Subject: FW: LU/218/20/PL & LU/219/20/L - Flintstone Centre - WITHDRAWALS

- Due to the siting, height and design of the proposed fencing/gates to the front right hand side of the building (which would be most visible in the street scene) the proposals would have a harmful impact on the significance/setting of the listed building and the character and appearance of the Conservation Area. The Conservation Officer has raised concerns in this regard, and the Council's Conservation Area Advisory Panel have raised an objection on these grounds. NB the sections of fencing and gate and the other sides and rear are considered acceptable (given their limited visibility and existing section of fencing/gate left hand side of building).

Status: PROPOSED

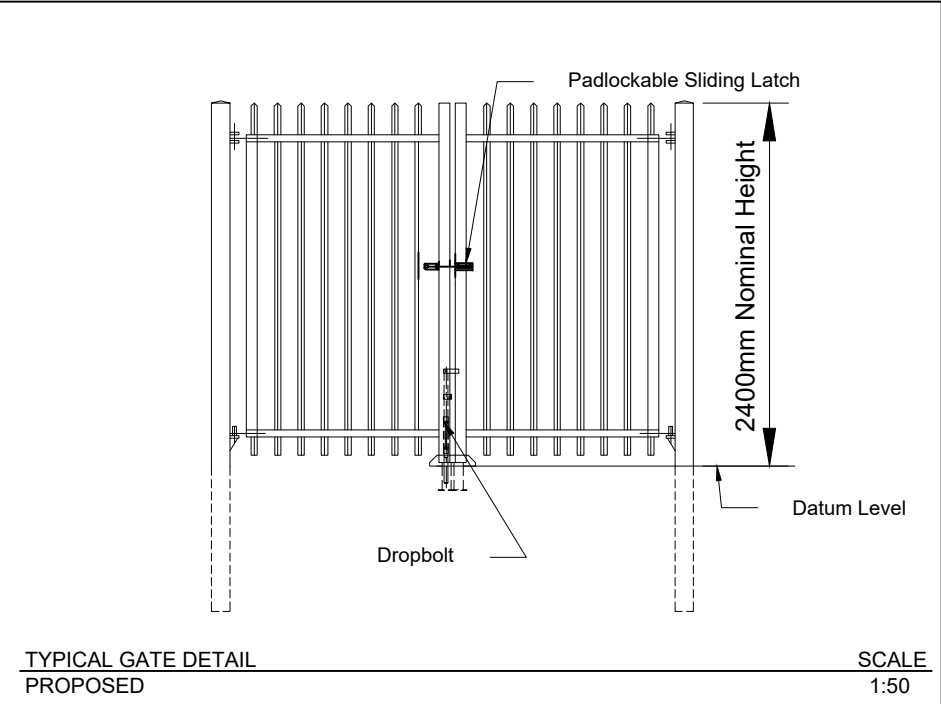
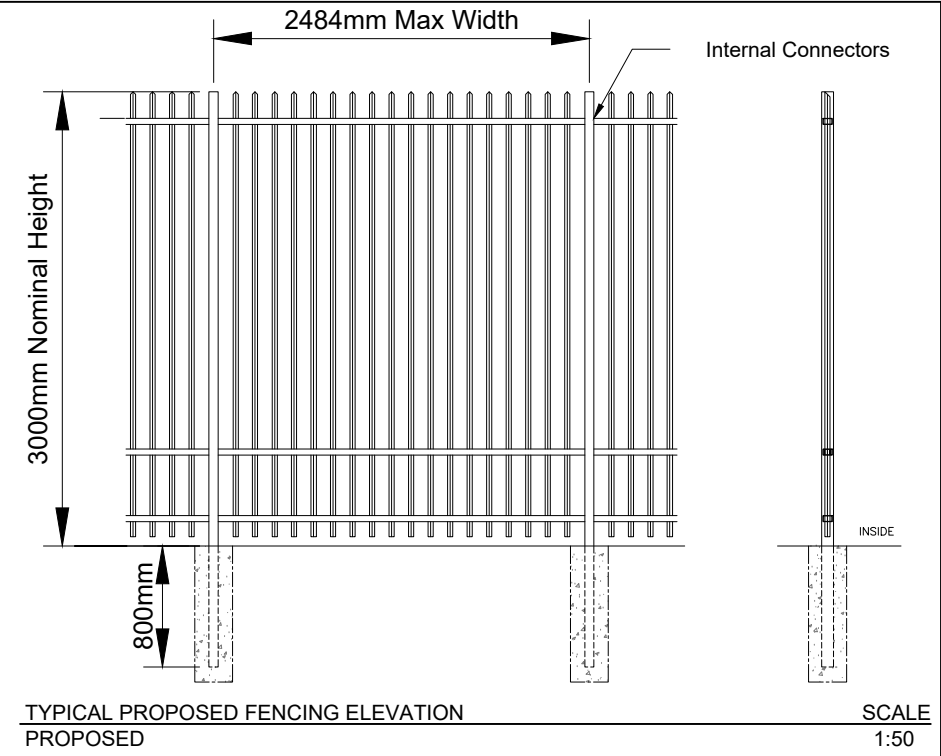
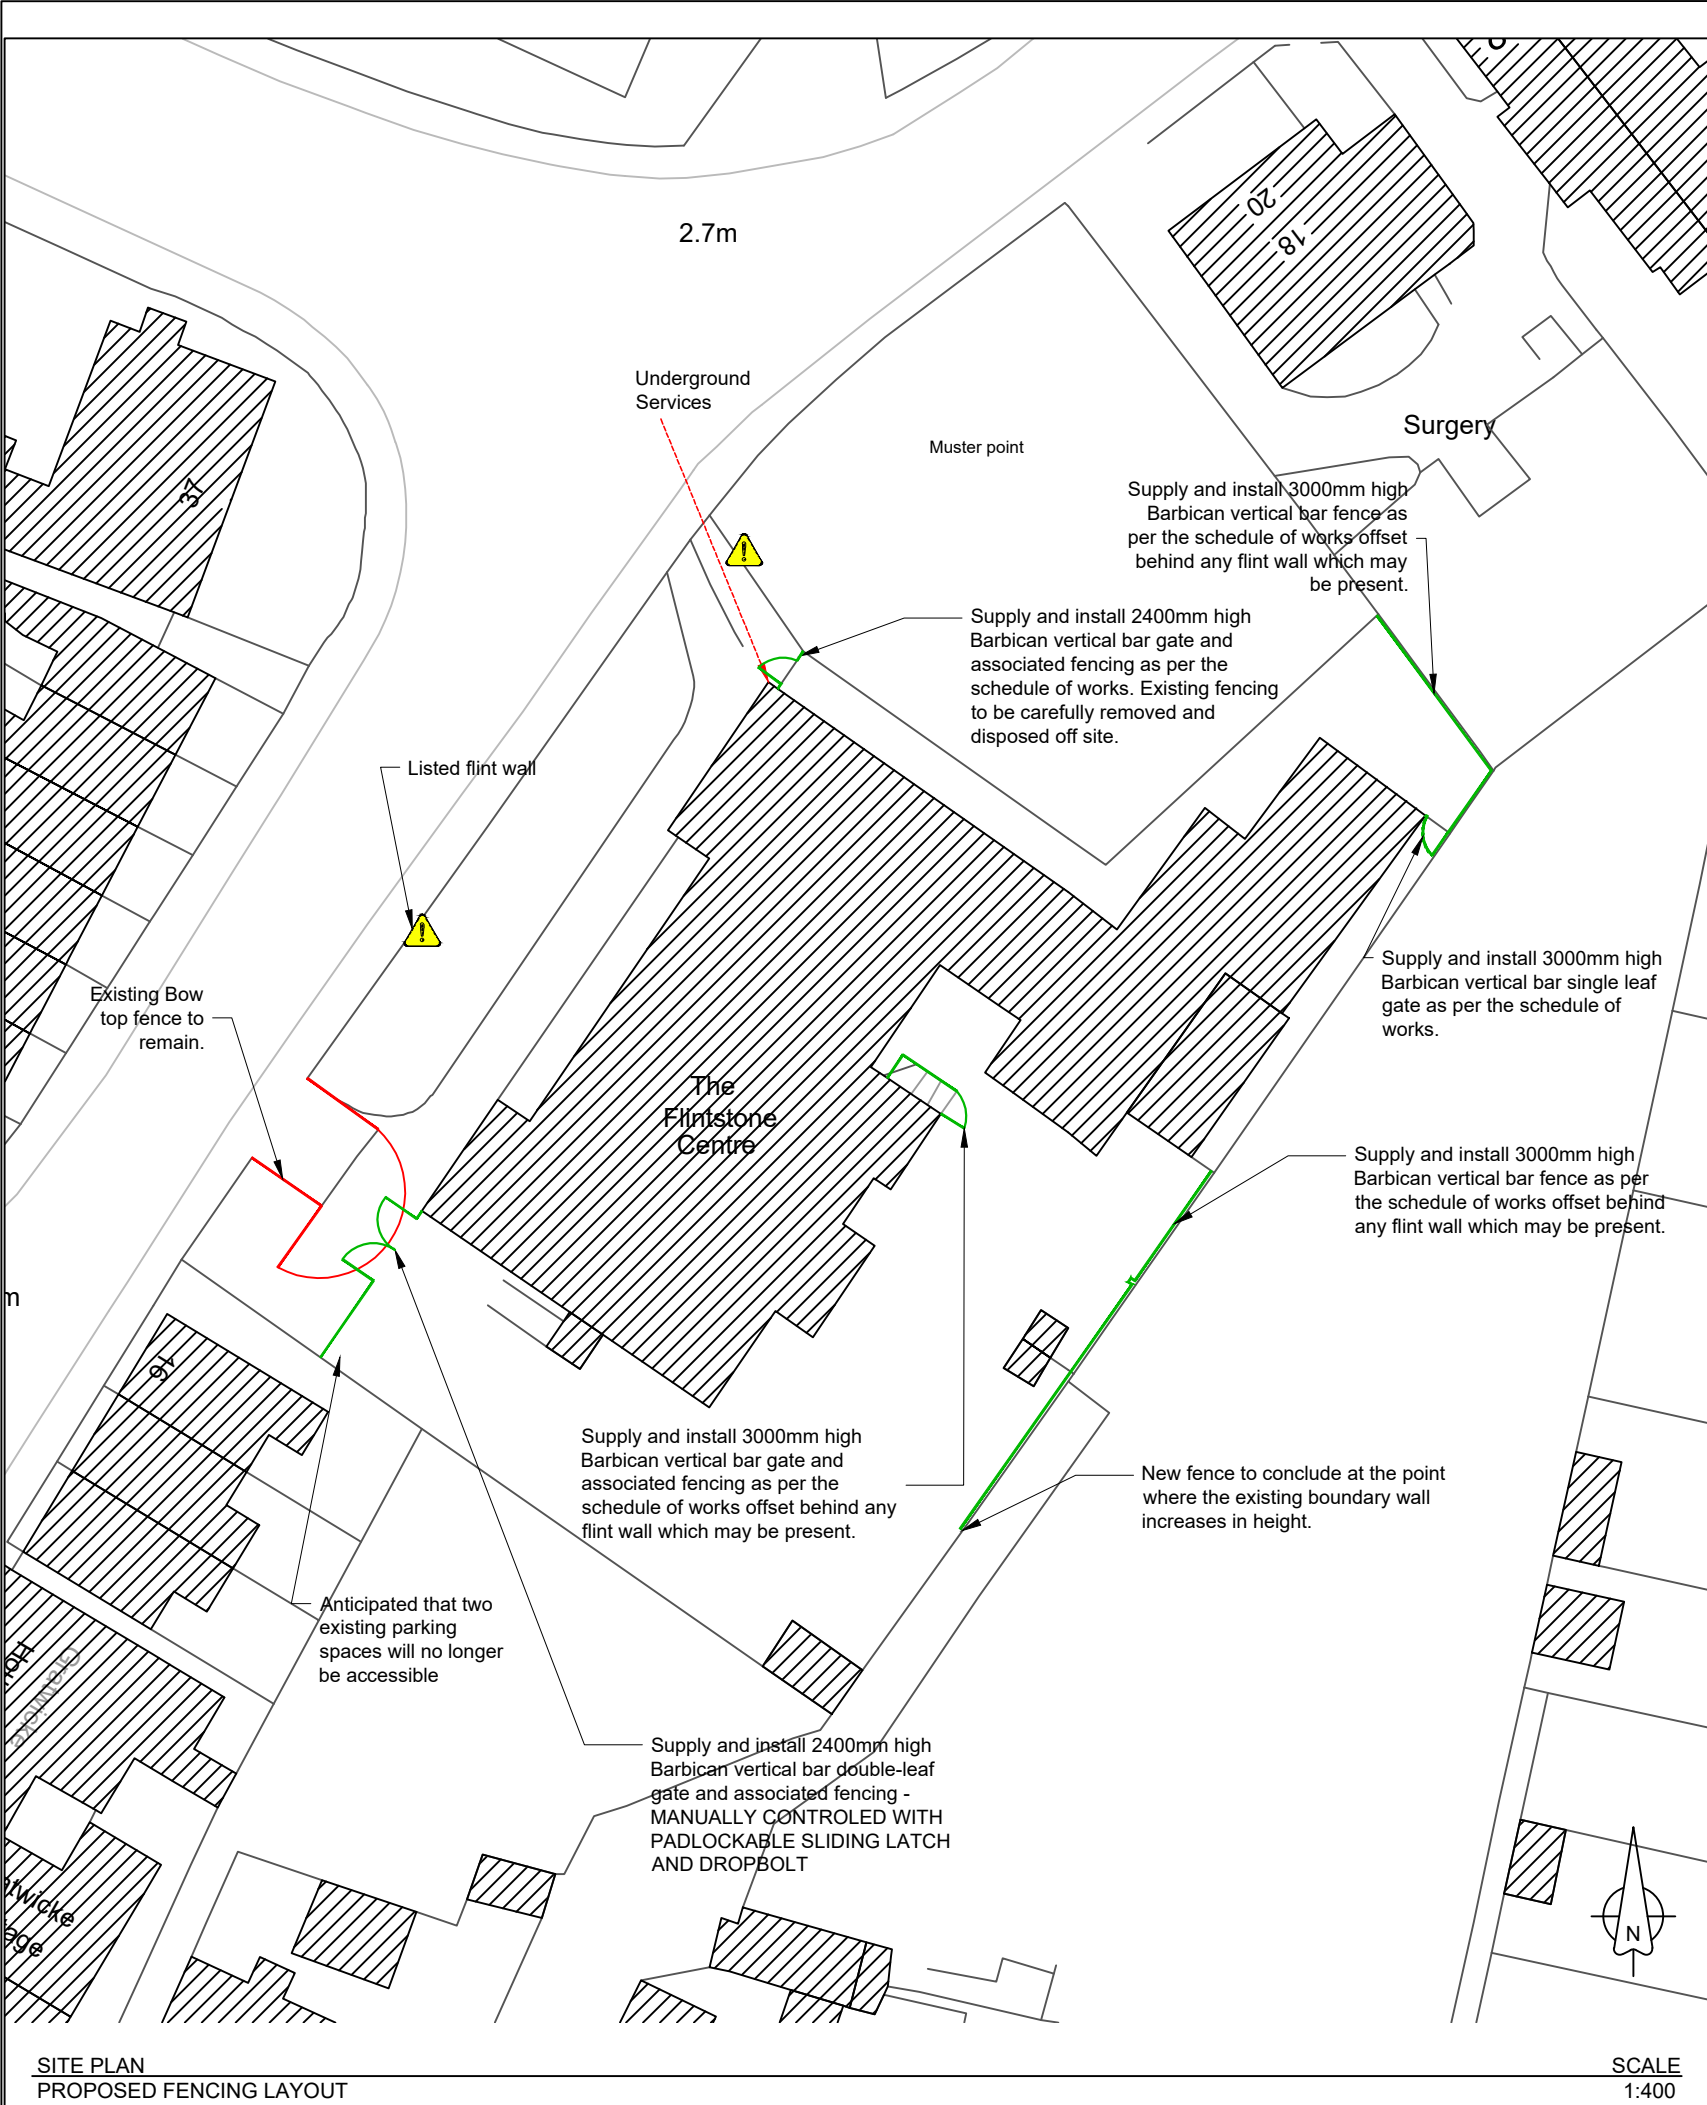
*NB I have discussed with my Manager of the possibility of you submitting new applications whereby this section of fence/gates is reduced in height, has an amended design, and re-sited set back from the façade/front building line of the building and that this may be acceptable in heritage terms (since this would reduce its visibility and prominence in the street scene, the impact on the listed building's façade, and the existing tree provides some screening).
